Please ask for: Mrs D Johnson
Email: daun.johnson@arun.gov.uk
Telephone: 01903 737762
Our Ref: AB/56/21/L
Your Ref:
Date: 23rd April 2021

Listed Building Consent for Alterations, Extension or Demolition of a Listed Building

Development: Listed building consent for the addition of 1 No. conservation rooflight.
Location: 61 Maltravers Street Arundel BN18 9BQ

BLOCK PLAN
SCALE 1:500

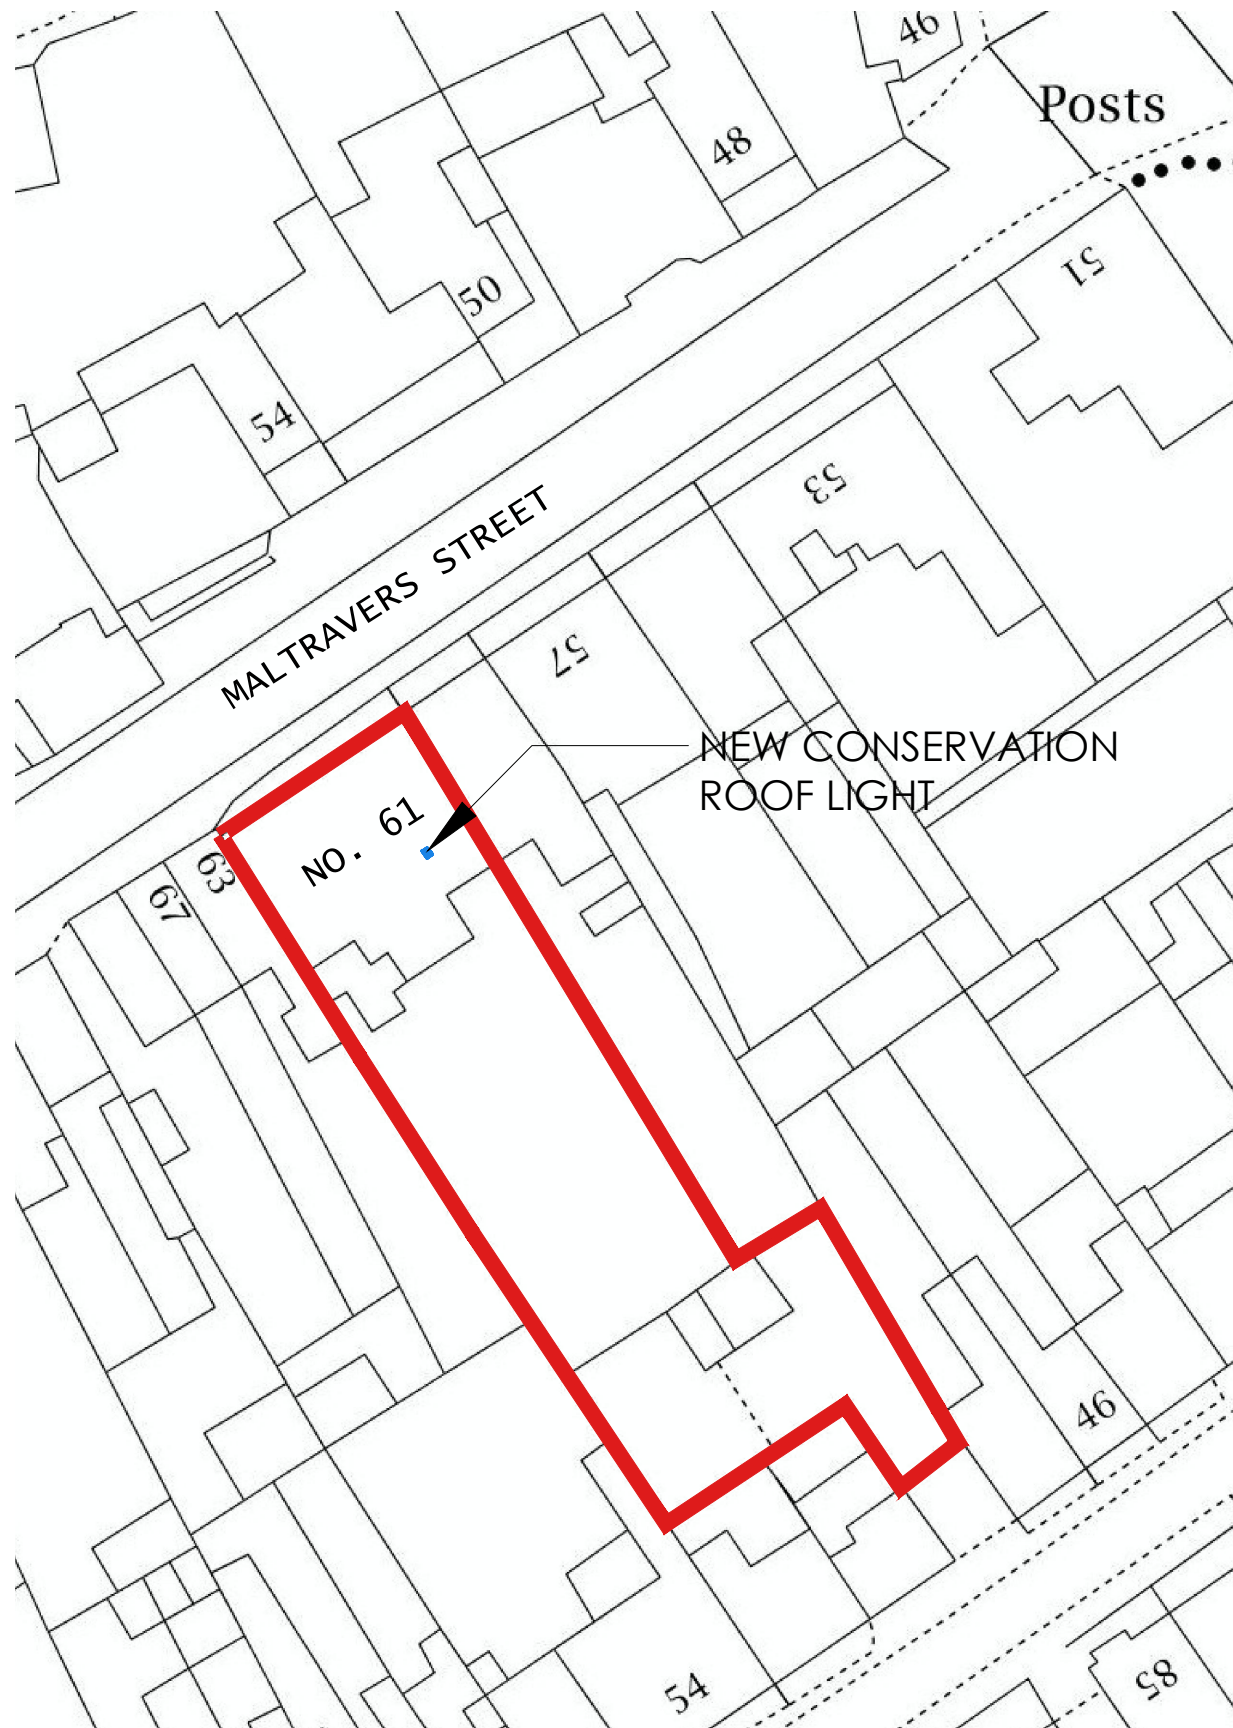
Block Plan

Please highlight the proposed works.
